An  
Bord  
Pleanála

**Board Direction**  
**BD-016417-24**  
**ABP-313361-22**

The Board decided to make a split decision, to **GRANT** permission for 87 residential units in the southern section of the site in accordance with the said plans and particulars based on the reasons and considerations under and subject to the conditions set out below and **REFUSE** permission for the proposed development located in the northern section of the site, for the reasons, and considerations under (1) & (2) below.

Drawing file: Architecture / 18034 PL102 OVERALL SITE LAYOUT (2 OF 2).pdf

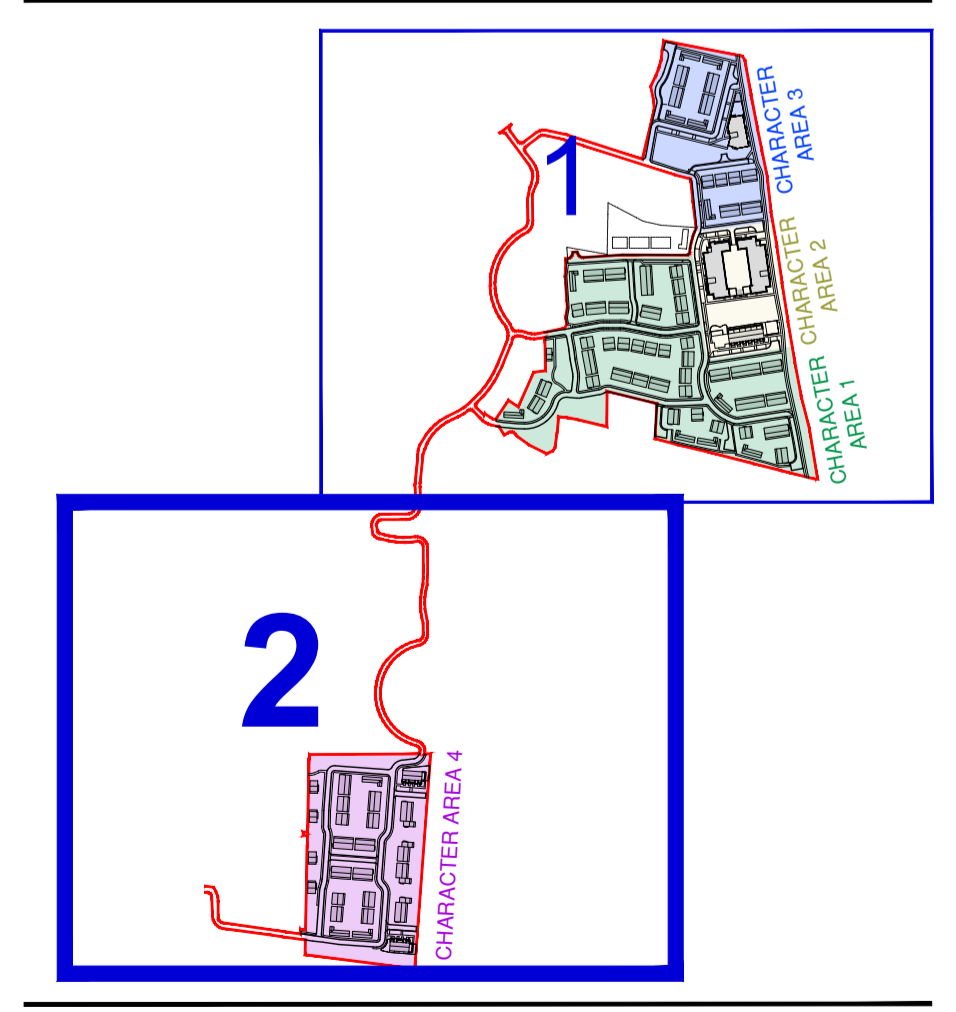
2. The number of residential units permitted by this grant of permission is 87 no. residential units and all associated works. (Identified as 2, Character Area 4 on Overall Site Layout (2 of 2) Drawing Number PL102.)

- (a) Rotate Block F so that it is orientated to the south;
- (b) Amend Blocks E and F so as there is a consistent roof ridge height and a hipped roof profile is provided.

- (c) The extent and nature of the use of the access between house number 71 and Duplex Block F, identified on the drawing PL102 as an agricultural access, shall be the subject of written agreement with the Planning Authority.

Revised drawings showing compliance with these requirements shall be submitted to, and agreed in writing with, the Planning Authority
